# CITY OF ALBUQUERQUE

June 29, 2017

**Re: GGP Sertiage JV Redevelopment**  
**600 Menaul Bld NE, Suite 5000 BP#201691798**  
**60-Day Temporary Certificate of Occupancy- Transportation Development**  
Architect's Stamp dated 07-25-16 (H18D005F)  
Certification dated 06-15-17

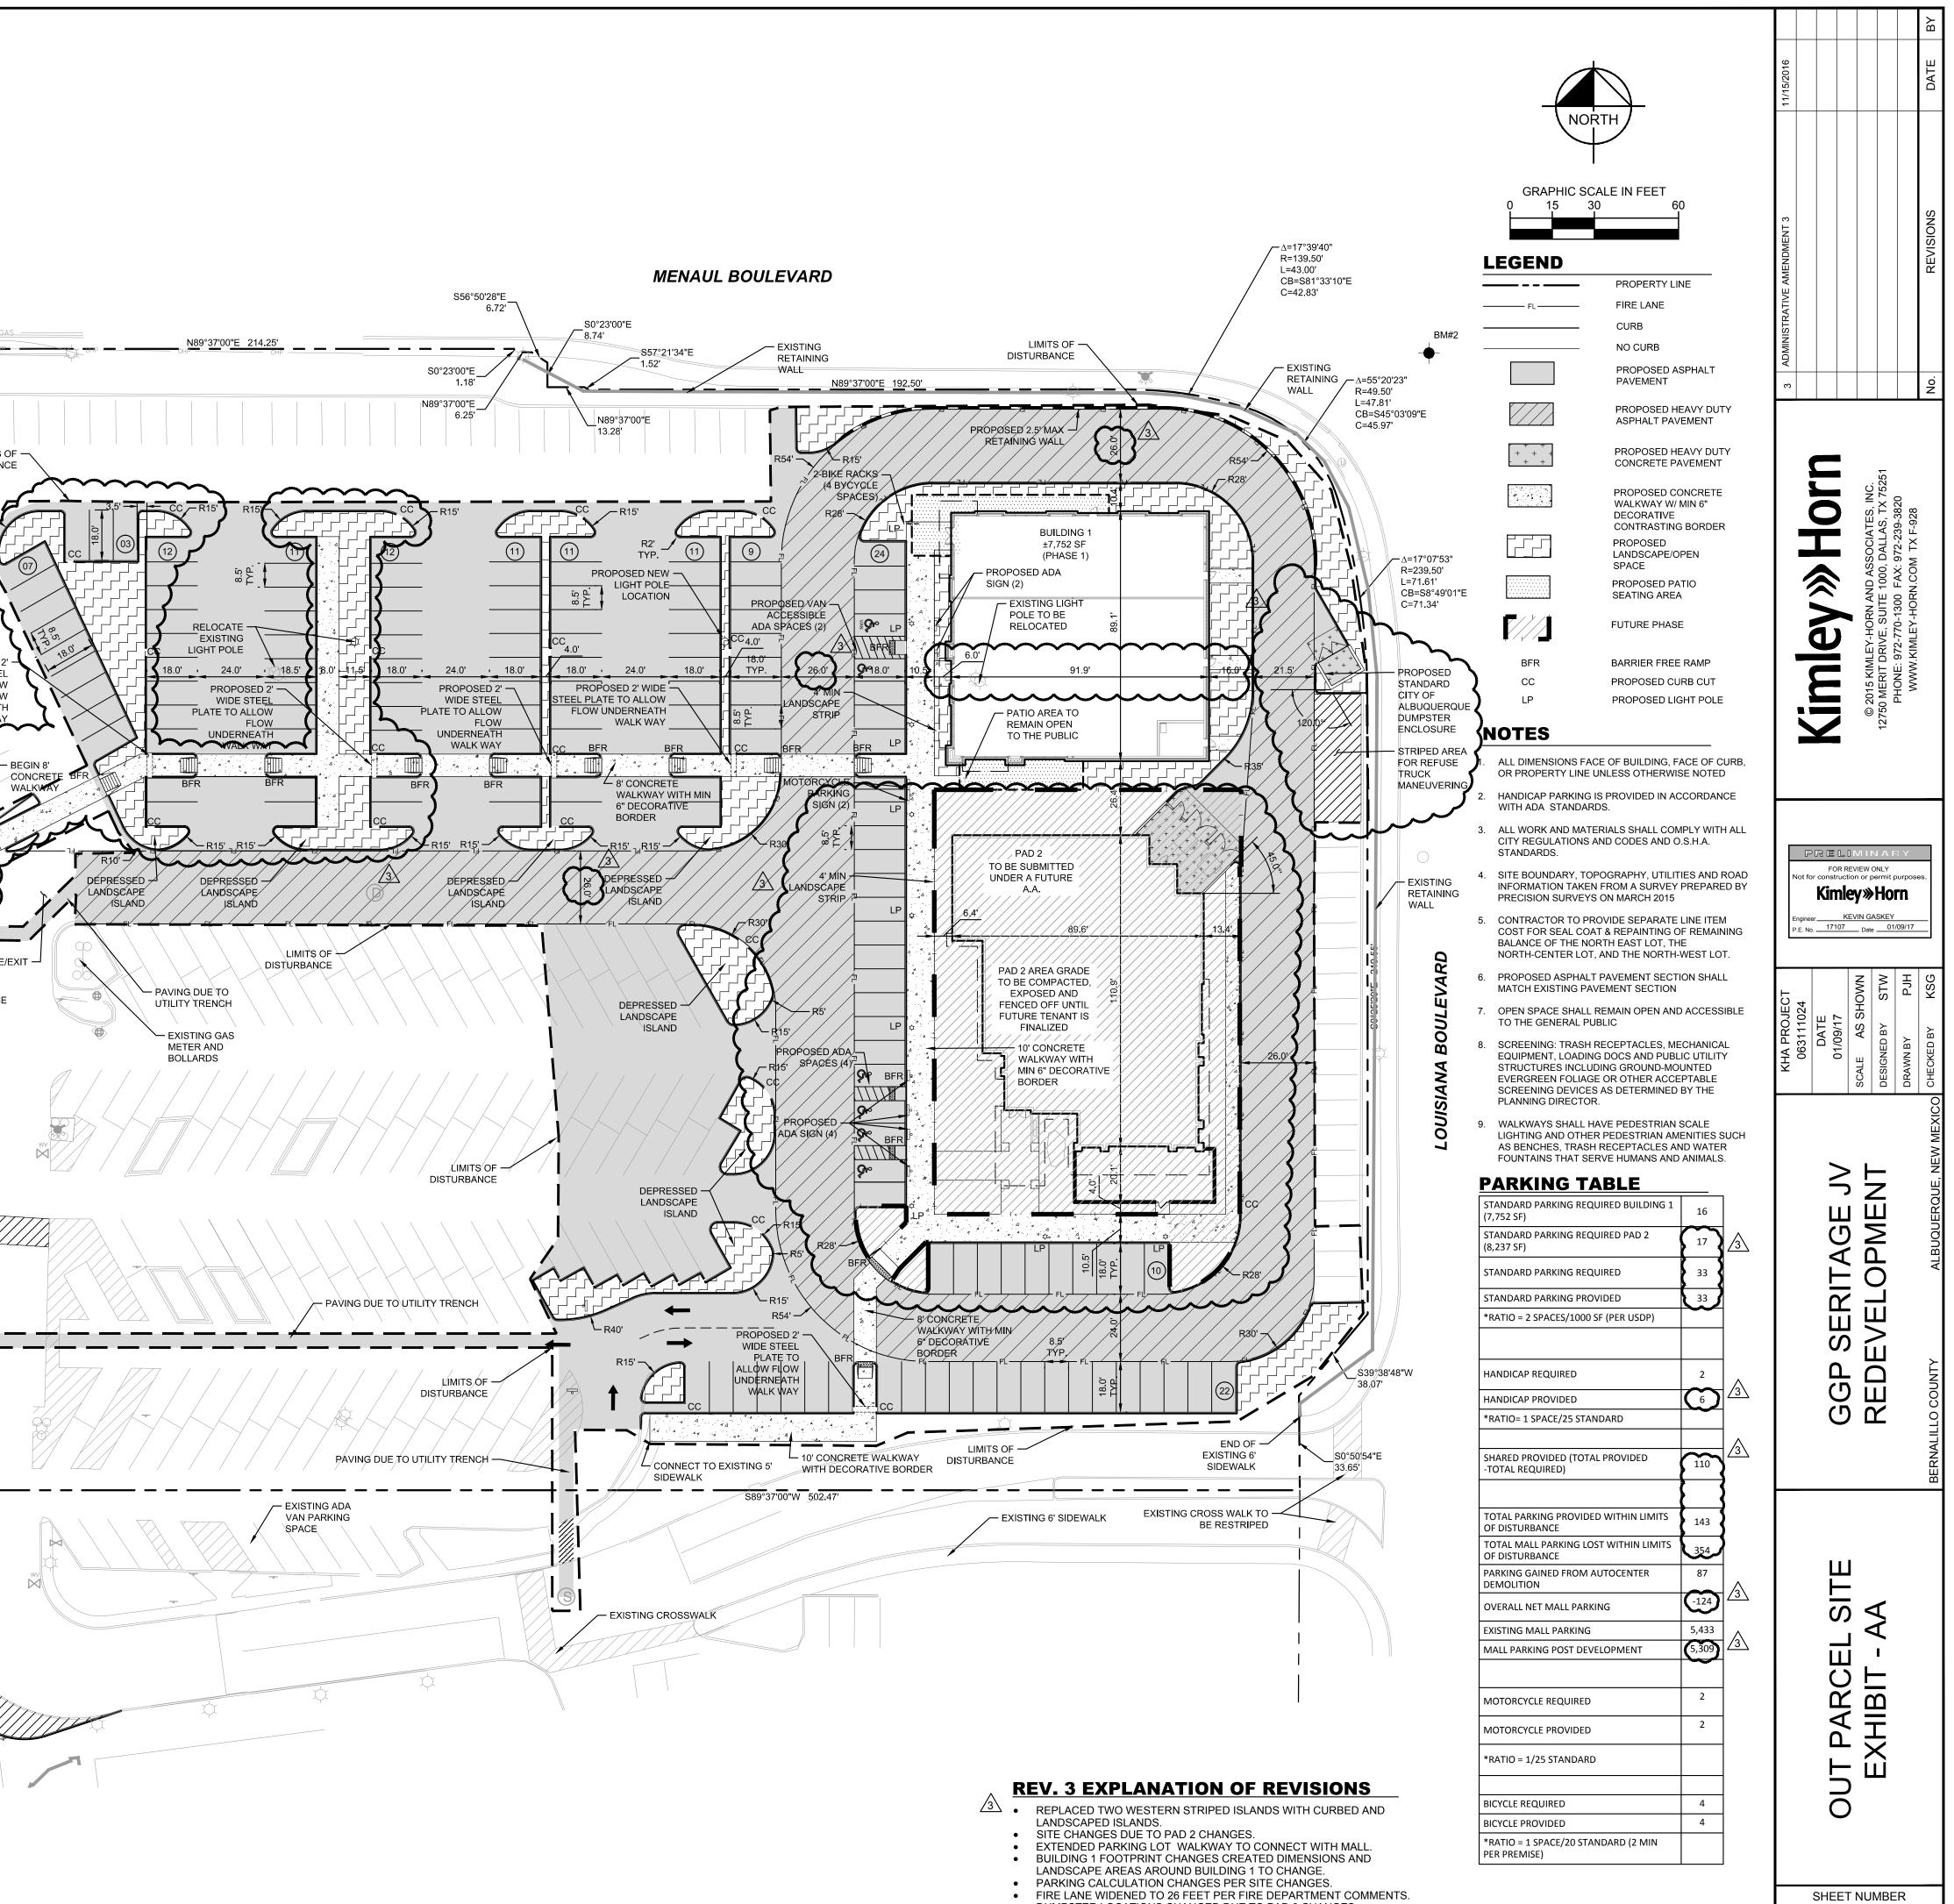
1. "NO PARKING" along the fire lane East of the building and South of the dumpster needs to be painted.
2. Paint parking spaces missing striping in parking lot see the attached photo.
3. The wheelchair ramp located in front of the building must not protrude into the ADA access aisle. See the attached exhibit for requirements of ADA ramps.
4. A convex mirror must be added at the location shown on the exhibit attached to the email.
